EP-22-0022_1 Latigo Trails Filing 9 SF2137

E½ Section 16, T12S, R64W, 6th P.M.

Proposed: 37 single-family lots within 102 acres

Submitted 11/17/2021 by Amy Crandall, Engineering Geologist, Colorado Geological Survey (303-384-2632 or acrandall@mines.edu)

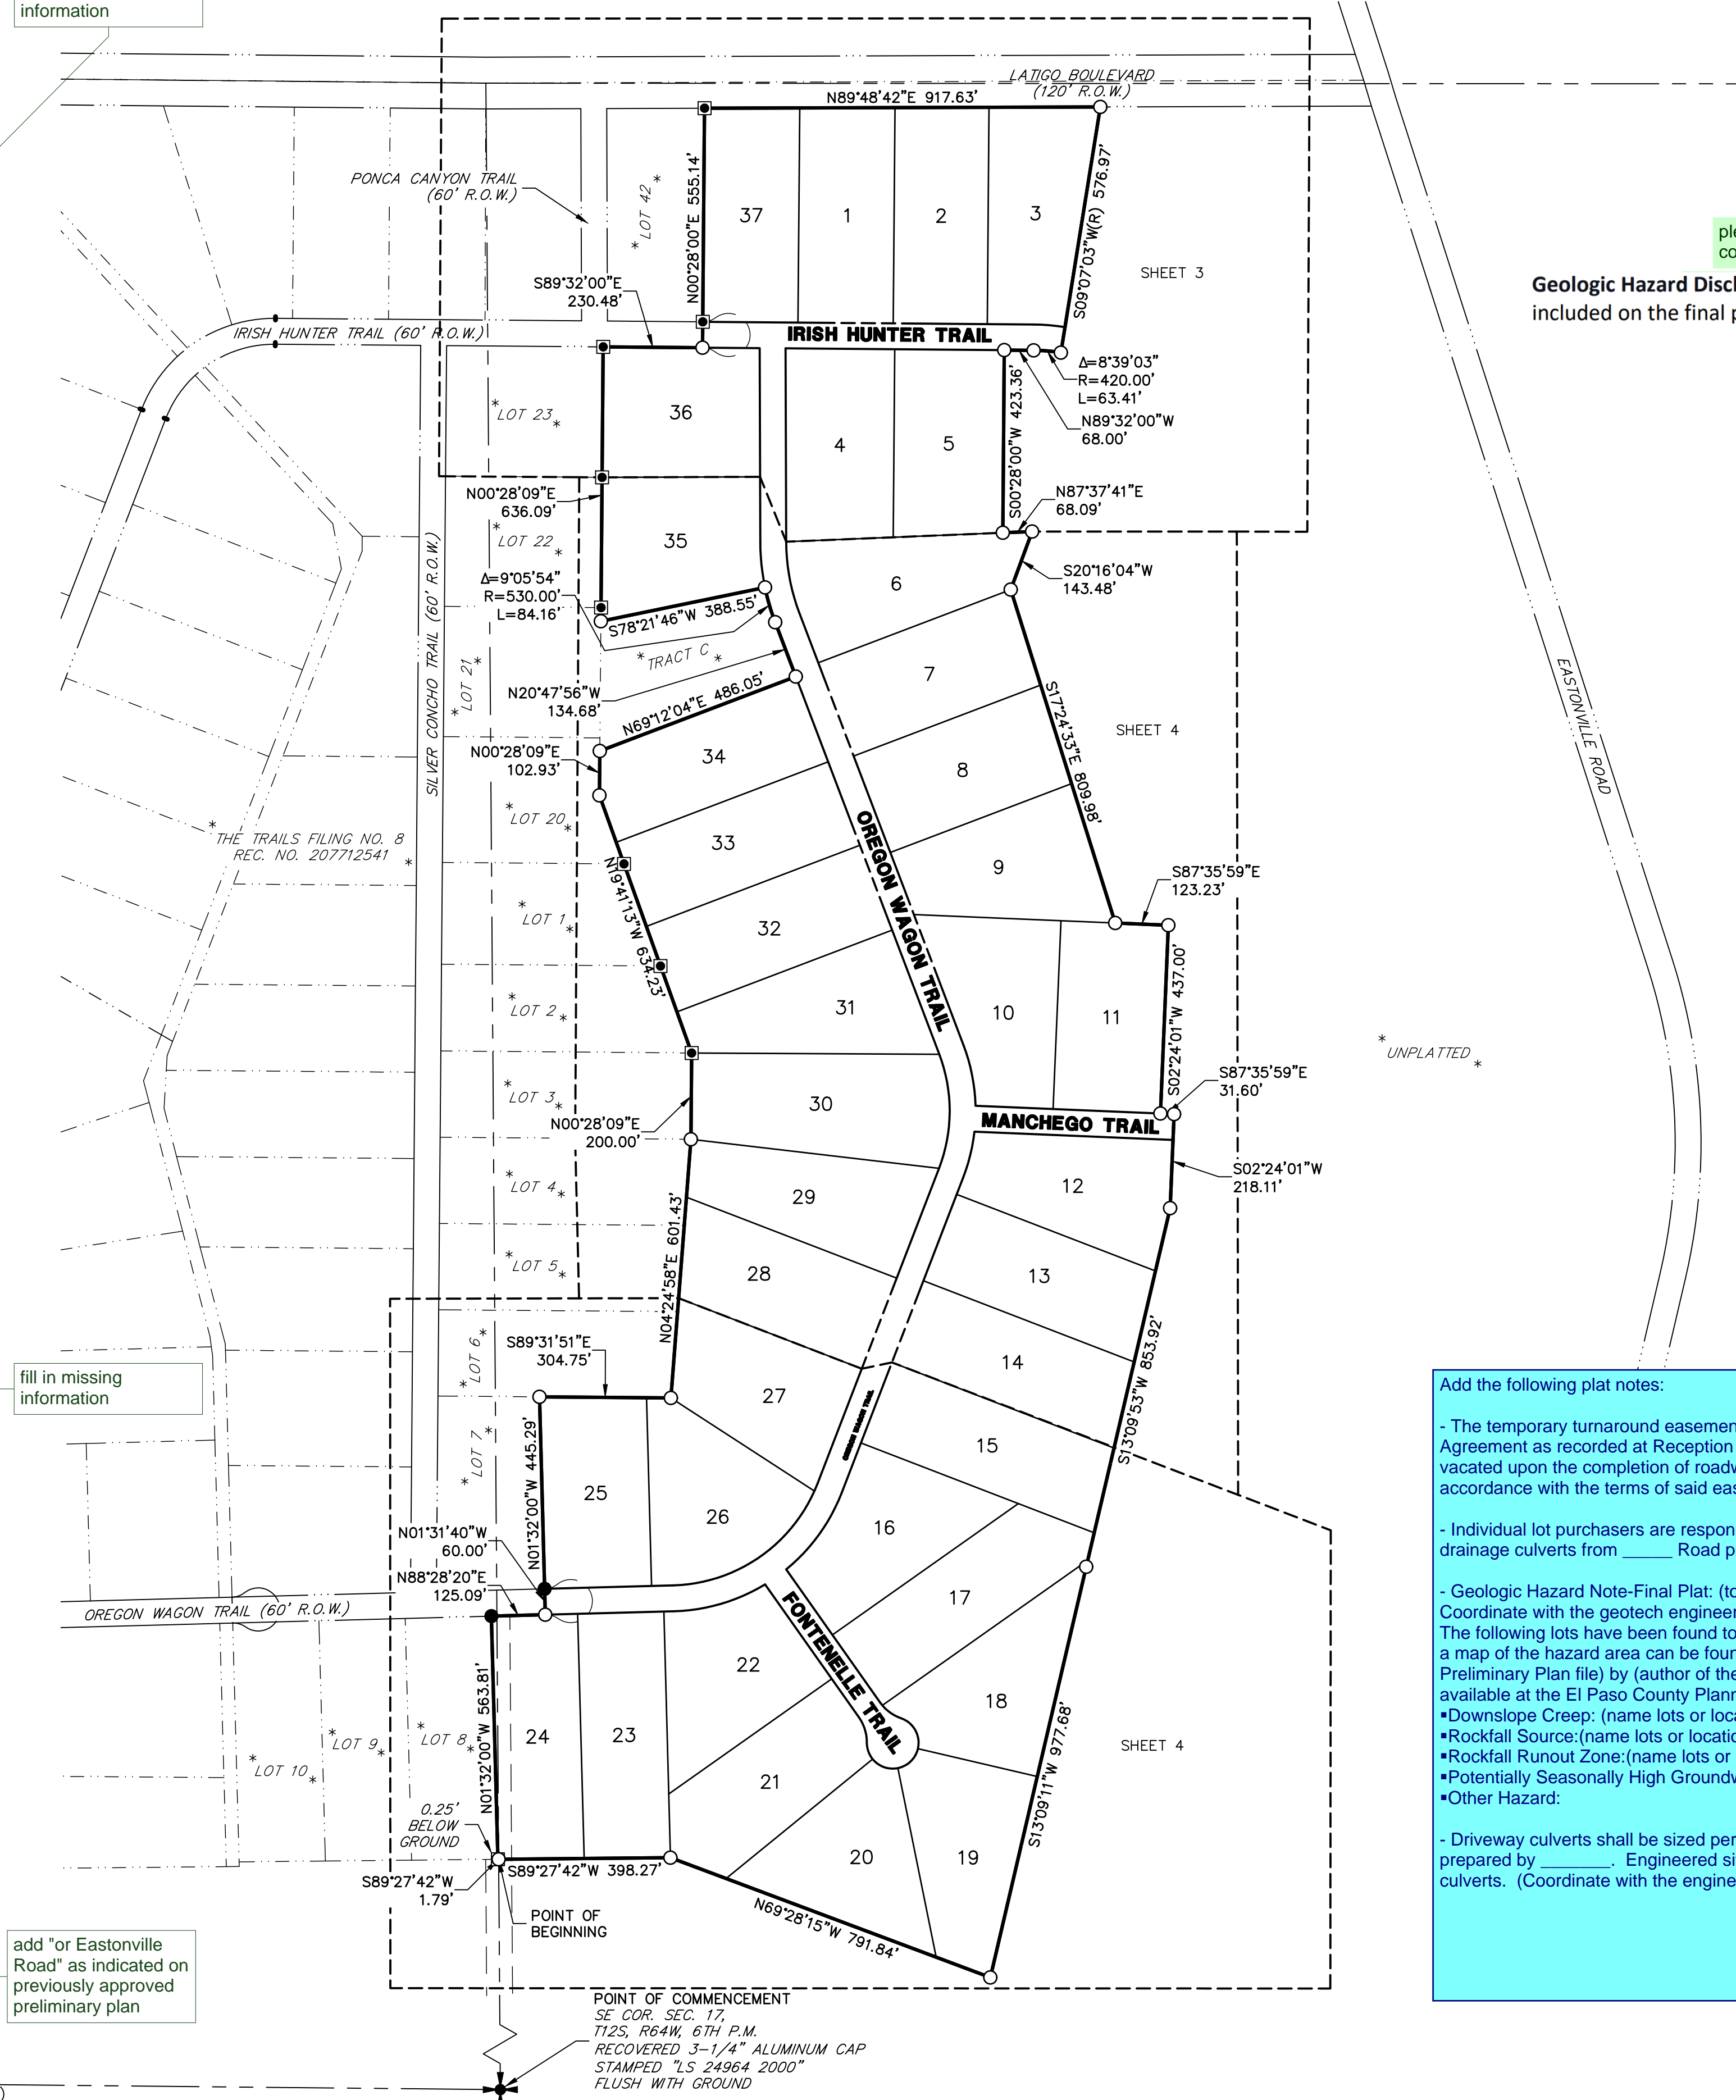
Geologic Hazard Disclosure Statement. CGS recommends a geologic hazard disclosure statement be included on the final plat referencing CTL's August 3, 2021 report.
